East Pye Solar
Applicant's Response to Advice and Observations at
Acceptance

Planning Inspectorate Reference: EN0110014

Document Reference: APP/8.1

Planning Act 2008: Application for a Development Consent Order for East Pye Solar - Response to Section 51 Advice

Drawing file: published-documents / EN0110014-000286-6.2.7.5.10 Environmental Statement Volume 2 Figure 7.5.10 Site 1 Zone of Theoretical Visibility (Revision 2).pdf

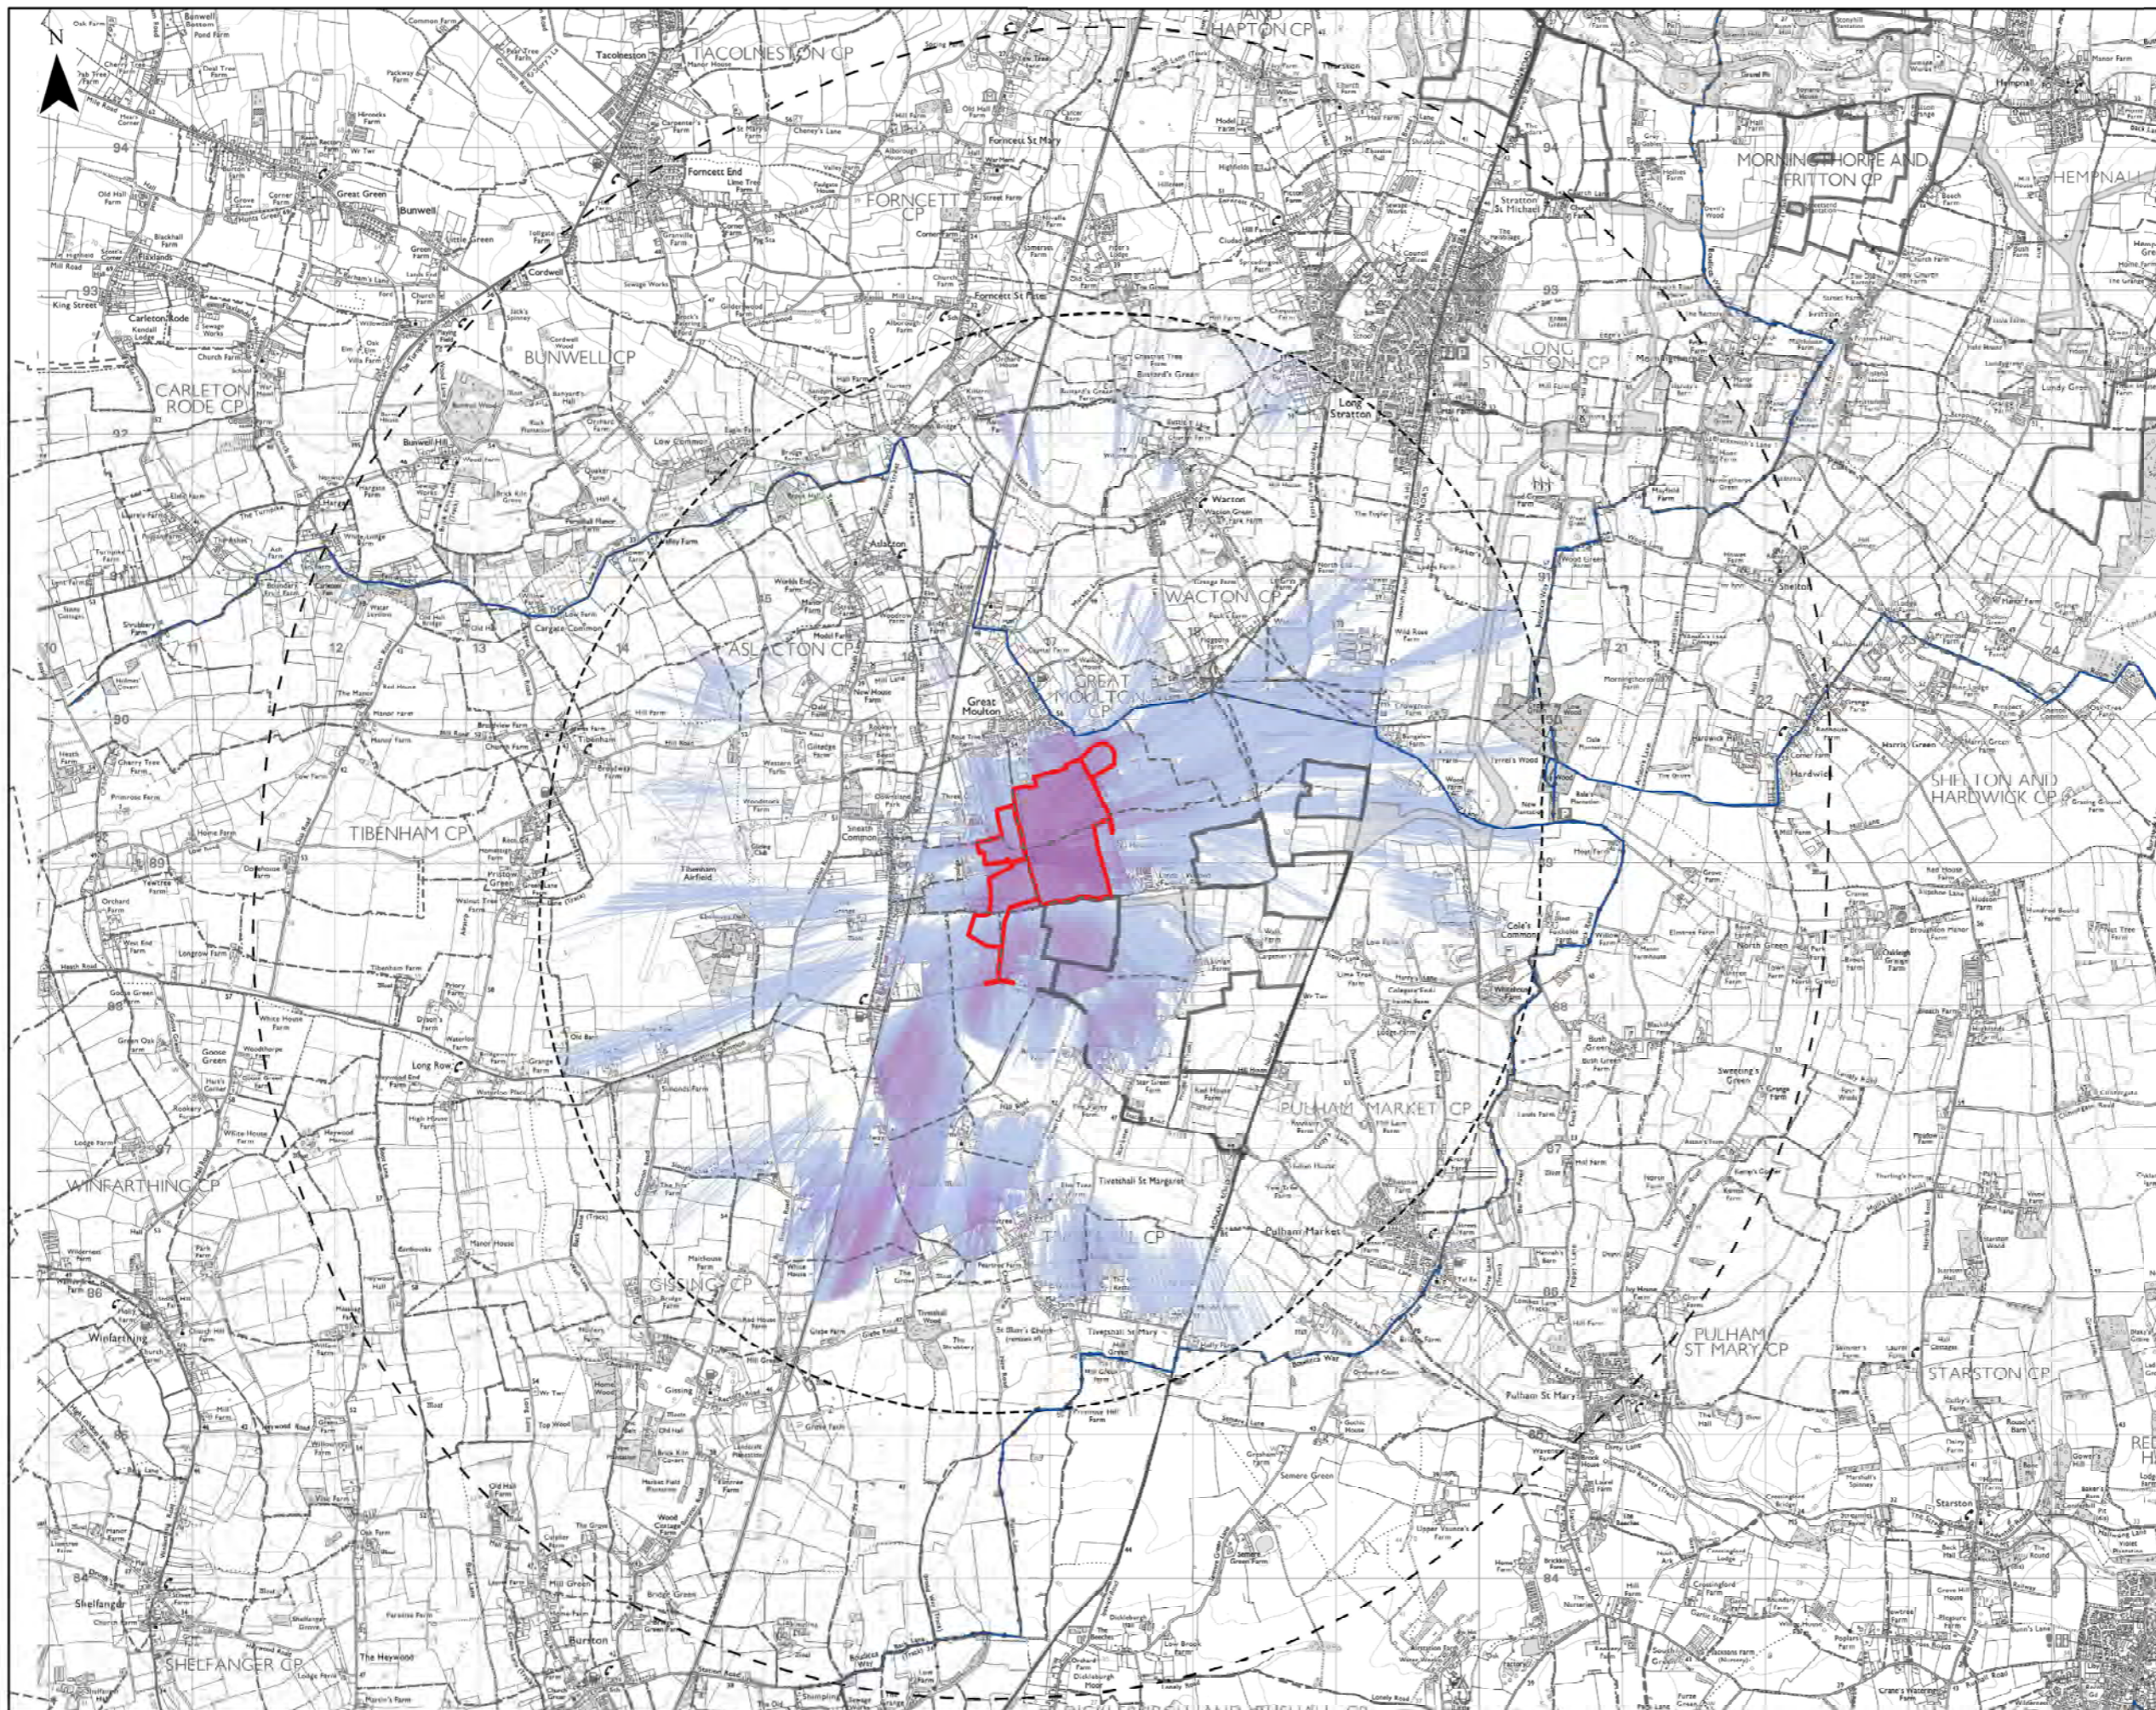
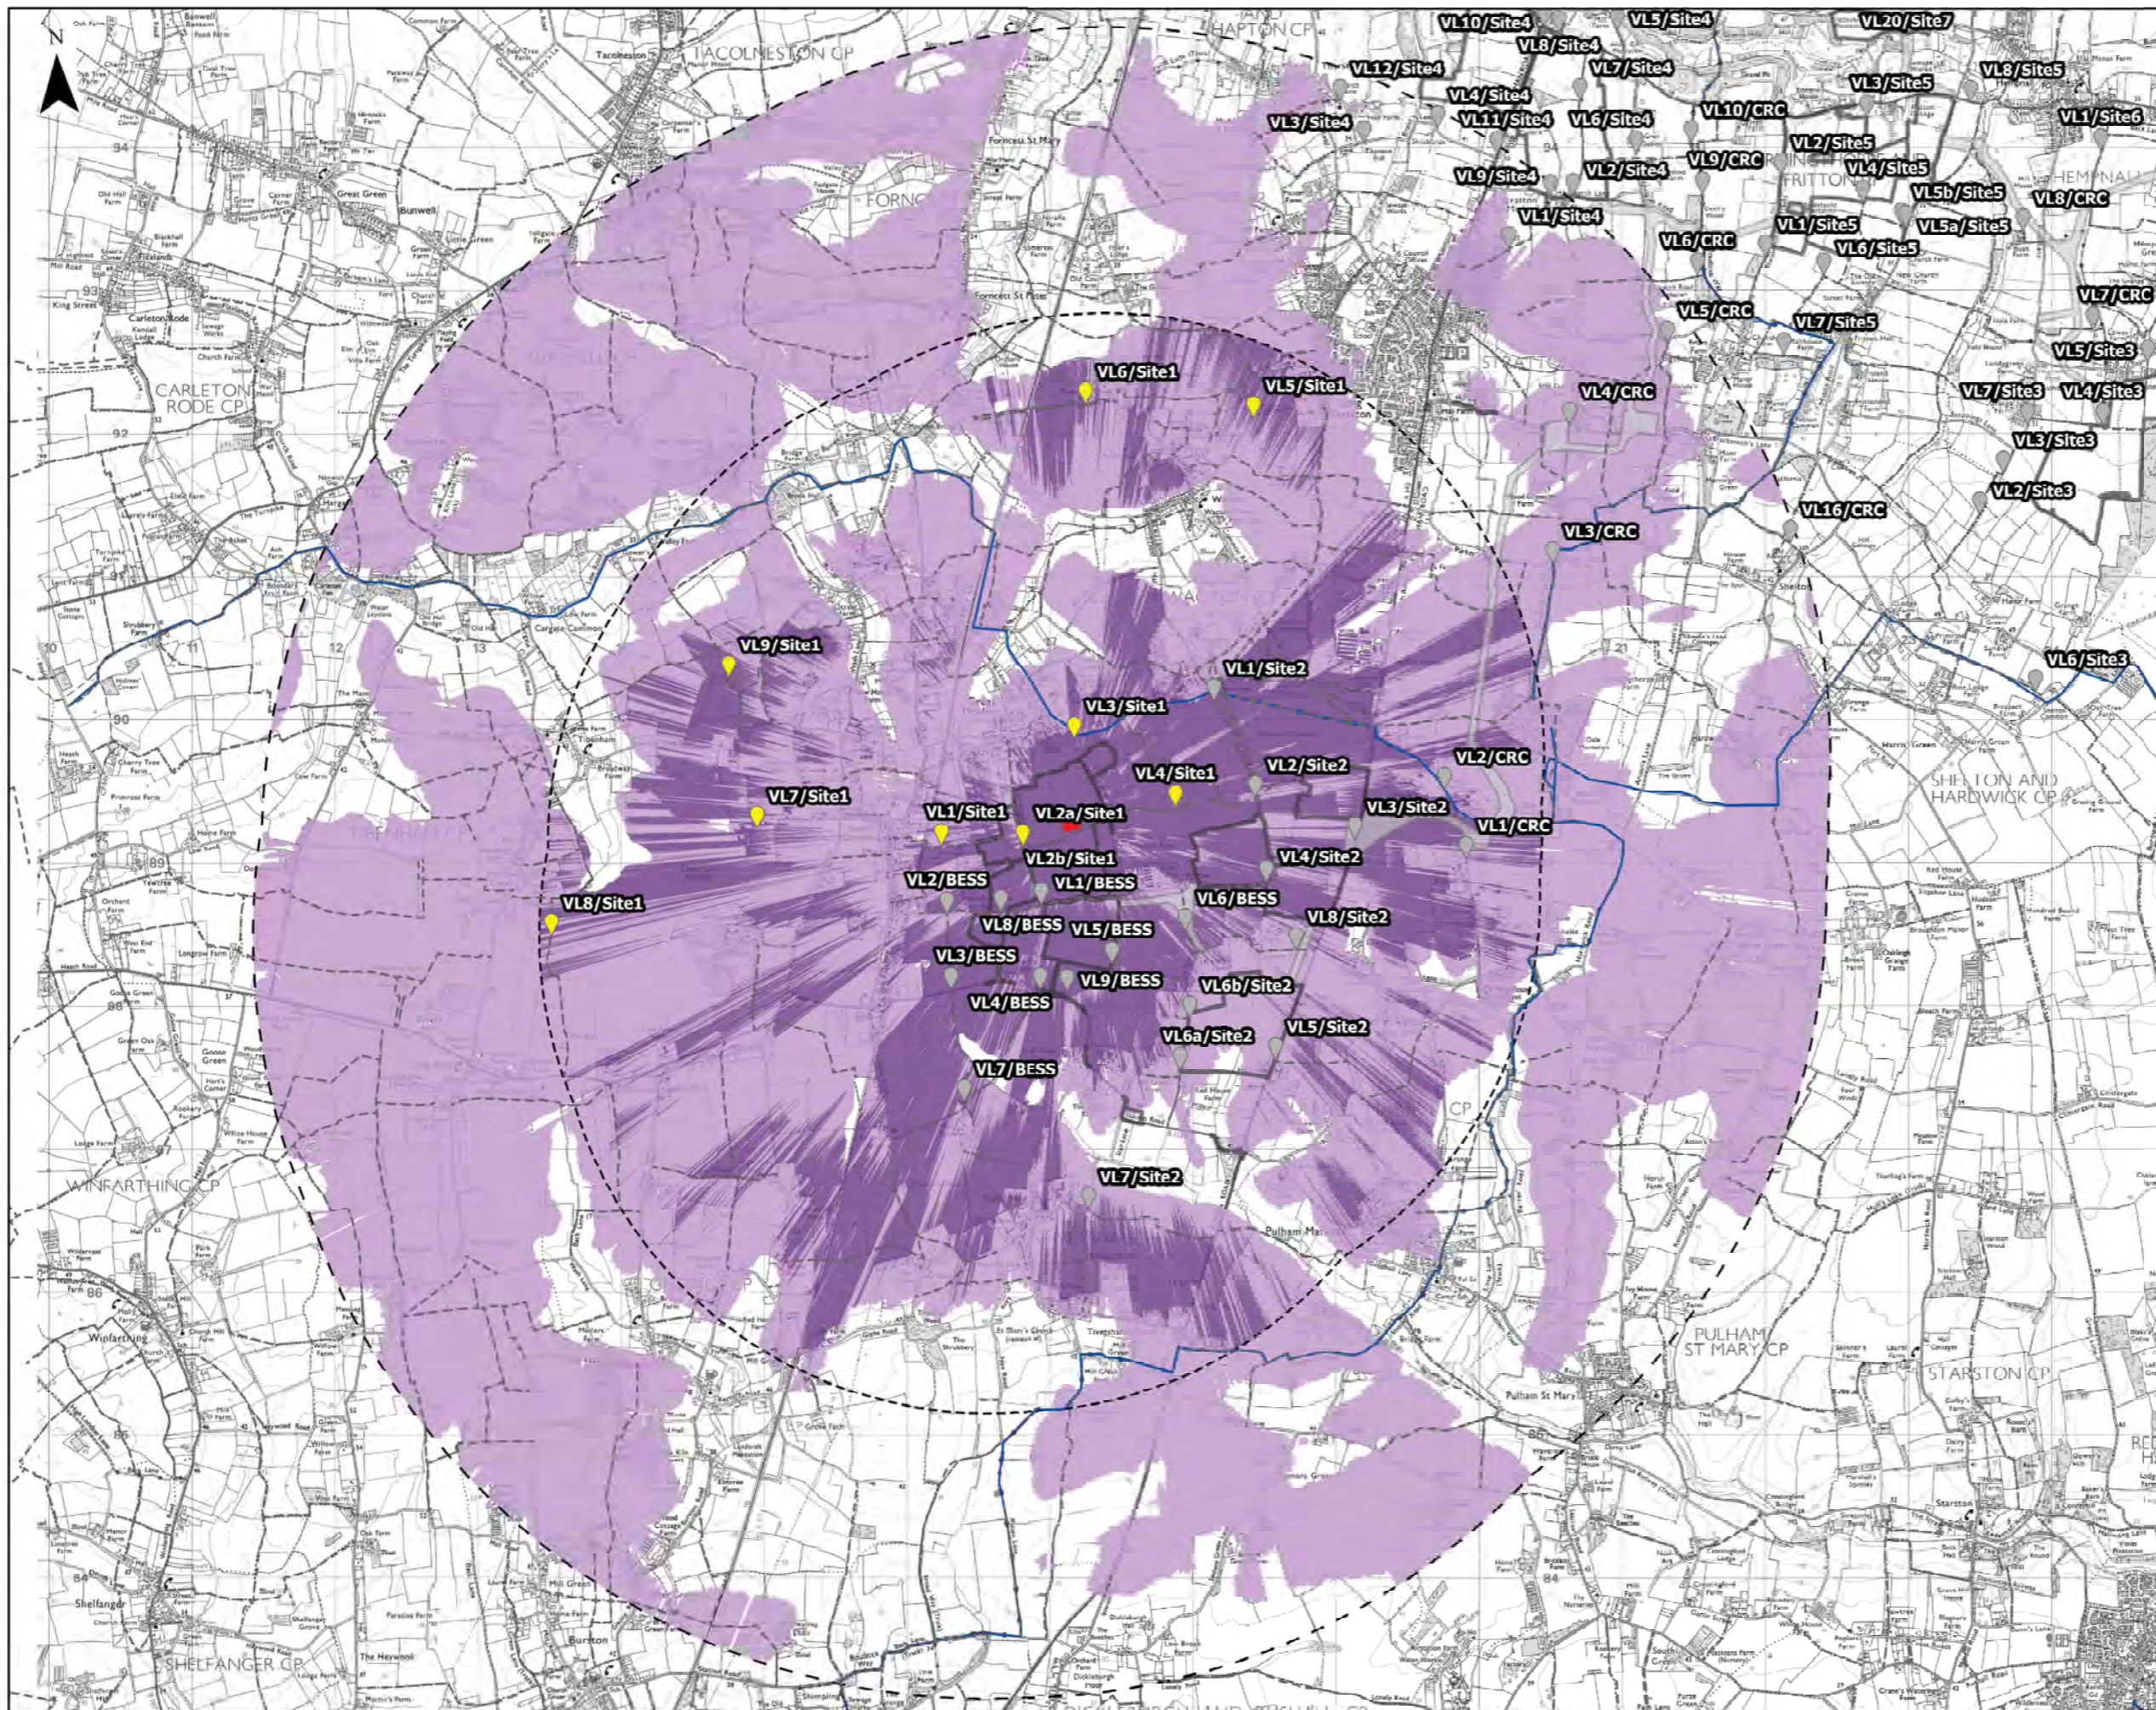
Plans and Figures The applicant is asked to submit revised Volume 2 and 6 documents that eliminate rendering issues and allow multiple files to be opened concurrently. This applies to several figures (such as documents 6.2.5.4, 6.2.7.5 (10), 6.2.7.6, 6.2.7.7, and 6.2.15.1), which range in size from 42.5 MB to 90.8 MB, plan document numbers 2.3 (69 MB) and 2.12 (78.1 MB), as well as to appendices attached to Environmental Statement chapters, such as document 06.03.18.01, which is 145.9 MB.	Reduced file size versions of the following DCO Application documents were provided to the Planning Inspectorate with the Applicant's initial response to the Section 51 advice [AS-001]. Where reducing the size of documents was not feasible, the document has been split into Parts. ■ Works Plan. Part 1 and Part 2 [AS-002 and AS-003]. ■ Hedgerow and Tree Protection Order Plan [AS-004].

Planning Inspectorate Comments	Applicant's Response
	■ Environmental Statement Volume 2: Figure 5.4 – Alterations to the Site Boundary between the PEIR and Submission [AS-006]. ■ Environmental Statement Volume 2: Figure 7.5.10 – Site 1 Zone of Theoretical Visibility [AS-007]. ■ Environmental Statement Volume 2: Figure 7.6 – Visual Receptors Plan [AS-008]. ■ Environmental Statement Volume 2: Figure 7.7 – View Locations and Visualisations [AS-009]. ■ Environmental Statement Volume 2: Figure 15.1 - ALC Results [AS-010]. ■ Environmental Statement Volume 3 Appendix 7.5 Photosheets – Cable Route Corridor. Part 1 and Part 2 [AS-011 and AS-012]. ■ Environmental Statement Volume 3 Appendix 7.5 Photosheets – Site 7. Part 1 and Part 2 [AS-013 and AS-014]. ■ Environmental Statement Volume 3 Appendix 7.6 Figure 7.6.7 Visualisations – Site 7. Part 1 and Part 2 [AS-015 and AS-016]. ■ Environmental Statement Volume 3: Appendix 8.1– Ecological Desk Study and Extended Habitat Survey [AS-017]. ■ Environmental Statement Volume 3: Appendix 9.1– Flood Risk Assessment & Outline Surface Water Drainage Strategy [AS-018 and AS-019]. ■ Environmental Statement Volume 3: Appendix 10.2 – Archaeological Desk-Based Assessment. Part 1 and Part 2 [AS-020 and AS-021].
